## Appeal Decision

**Appeal Ref: APP/R4408/W/20/3244987**

**54 Jebb Lane, Haigh, Barnsley S75 4BU**

- The appeal is made under section 78 of the Town and Country Planning Act 1990 against a refusal to grant outline planning permission.
  - The appeal is made by Mr Simon Brown against the decision of Barnsley Metropolitan Borough Council.
  - The application Ref 2019/1102, received by the Council on 30 August 2019, was refused by notice dated 25 October 2019.
  - The development proposed is a detached triple garage.
-

Project Proposed Triple Garage For:- Mr & Mrs. S Brown At:- 54 Jebb Lane Haig, Barnsley	Scale As Shown	Date Aug 19
	Drawing Site and Location plans	
	Dwg.No.	3

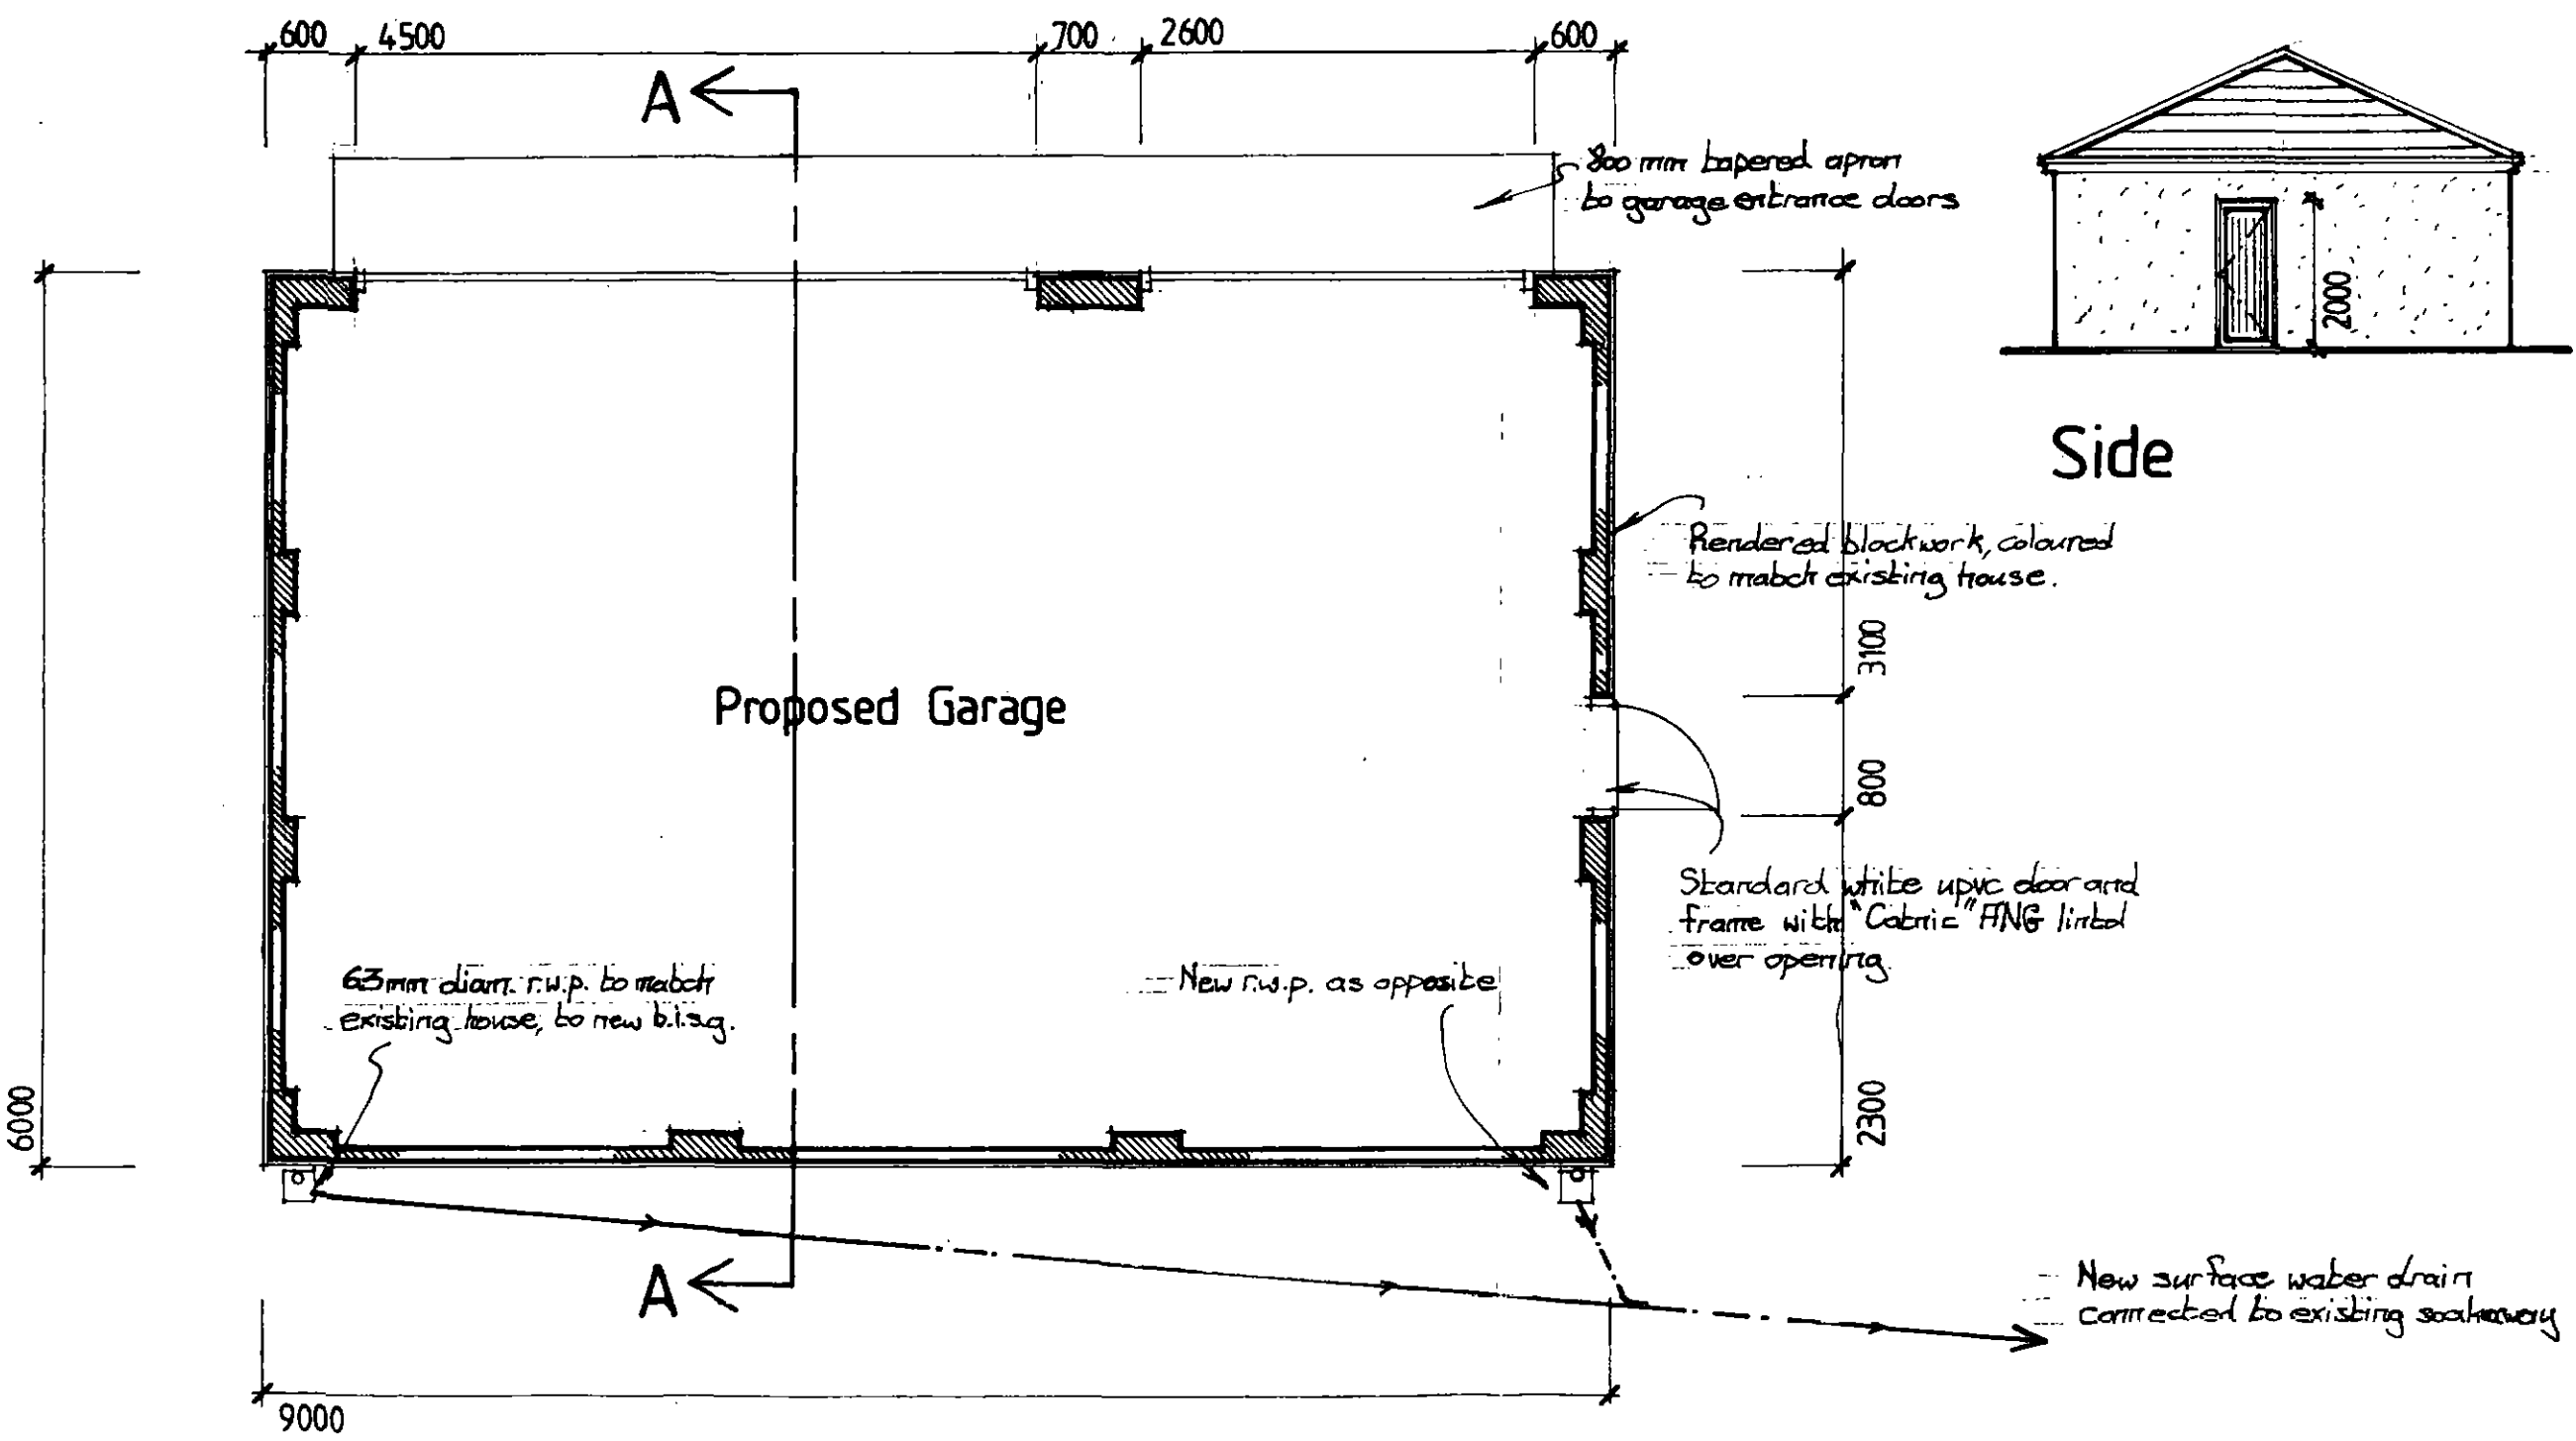
13. The proposed garage would be 9m wide by 6m deep with white up and over doors, concrete interlocking tiles with rendered walls to match the house. This being to the front and centrally within the site would be clearly visible and with the materials and white doors detailed have a marked and negative impact on this location.

Client	Mr & Mrs S. Brown	
	Proposed triple garage At:- 54 Jebb Lane Haig Barnsley	
Drawing	Prop. floor plan and elevations	
	Scale	Date
1:50 & 1:100	Aug 19	
Drg. No.	1

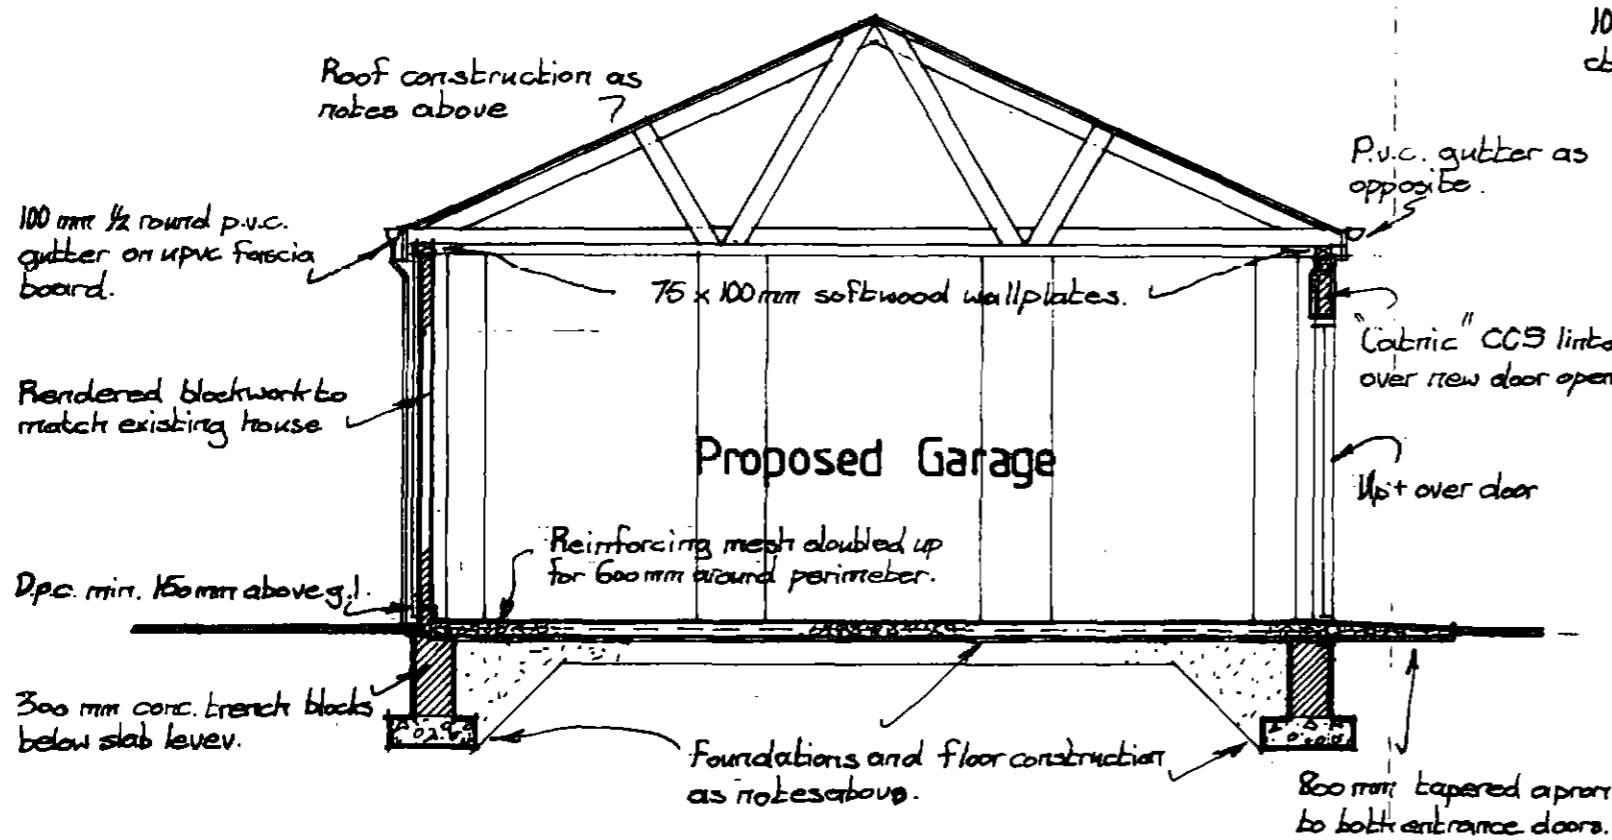
14. The house extensions and other domestic alterations SPD (2019) seeks to ensure outbuildings have a sympathetic approach in style and external finish. With the materials proposed and the hipped roof design this would not reflect the details of the host property and would further detract from the character and appearance of the area.
